8 March 2021

SF2016/057834; WST16/00066/10

**SSD-10417: Lot 222 DP 1247780 and others; 22L Sheraton Rd, Dubbo  
Proposed Dubbo Quarry Continuation Project (Holcim)**

Figure 1: Product transport route

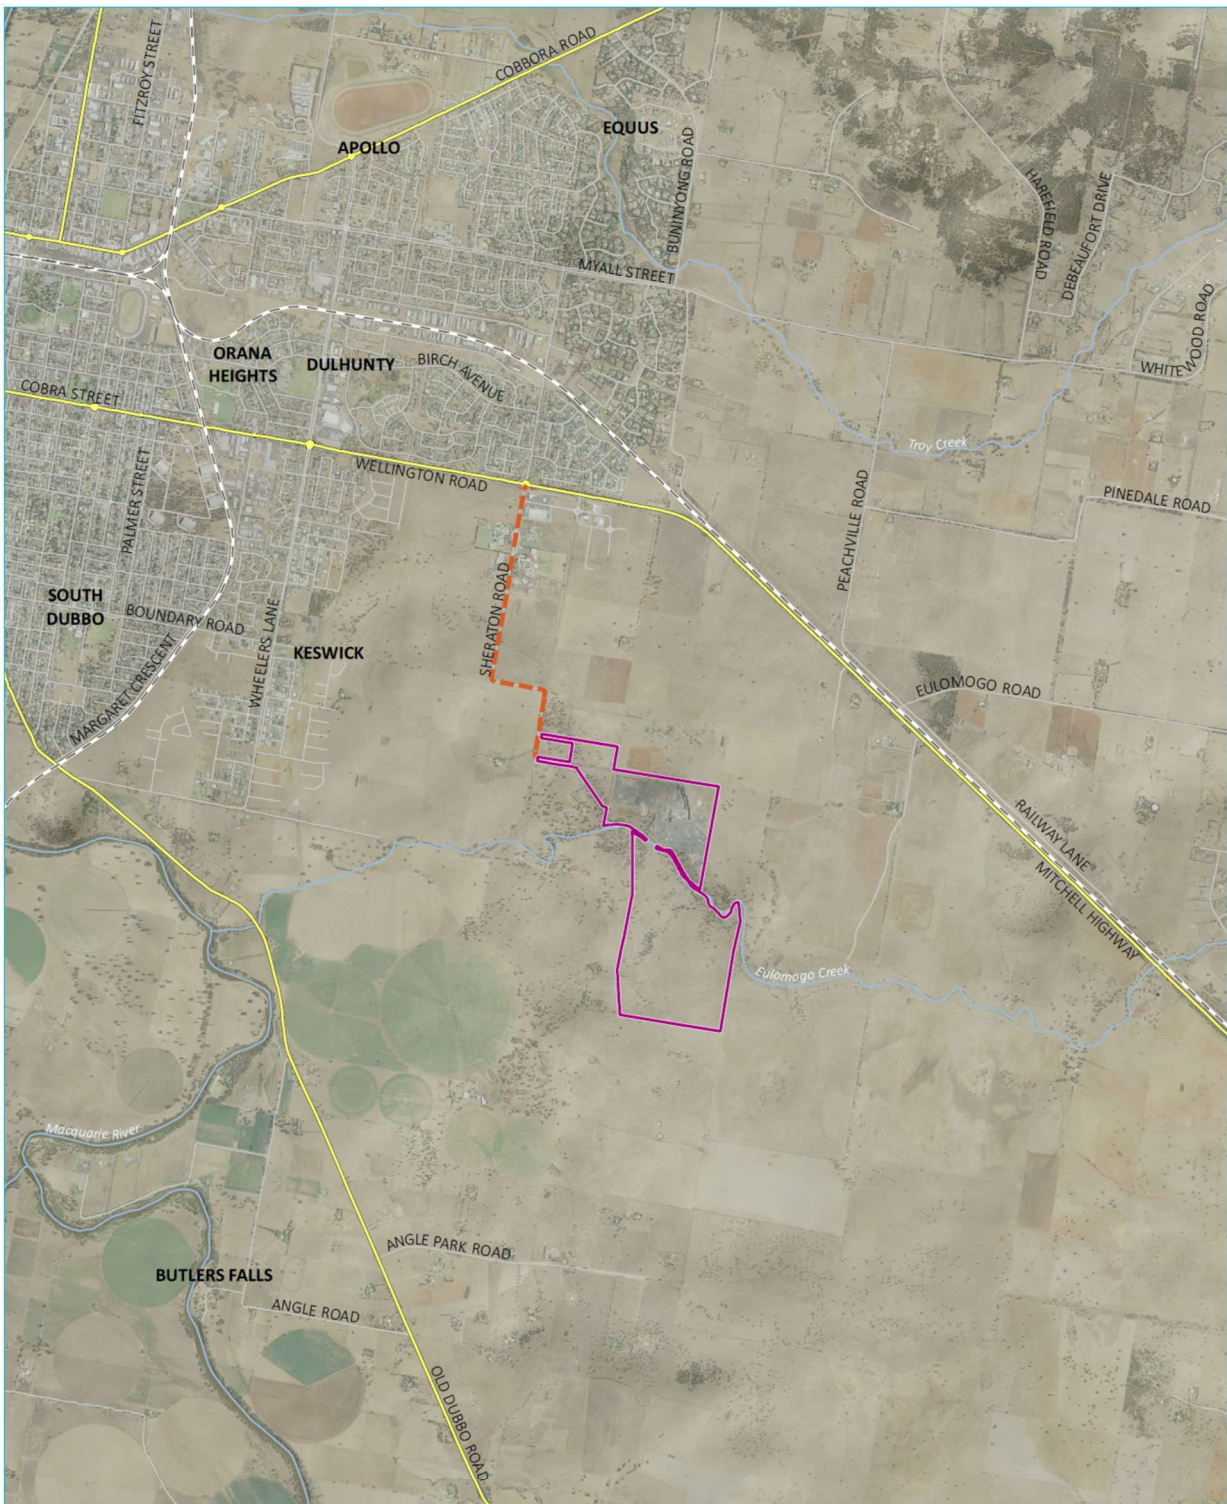
- The Road Safety Audit (RSA) provided by the applicant raises safety concerns with mixing of quarry and school traffic or pedestrians at peak times. If different road users are separated the potential for incidents will be substantially reduced. The applicant has not proposed management measures and/or works to address these risks or justified why such commitments are unnecessary to keep the risks as low as reasonably practicable. Any measures may be included as consent conditions or incorporated into a Traffic Management Plan in consultation with schools, bus operators, businesses, Council and TfNSW.

- The proposal includes use of trucks up to 20 metres long. The Sheraton Rd route is not approved for trucks greater than 19 metres or 50 tonnes on either the TfNSW Restricted Access Vehicle (RAV) or Performance Based Standards (PBS) maps, available online. If the route is to be reclassified to allow PBS Level 1 trucks (up to 20m), it is requested this be initiated through Council, and gazetted prior to commencement of haulage. The applicant is to clarify how the National Heavy Vehicle Regulation (NHVR) rules will be met.
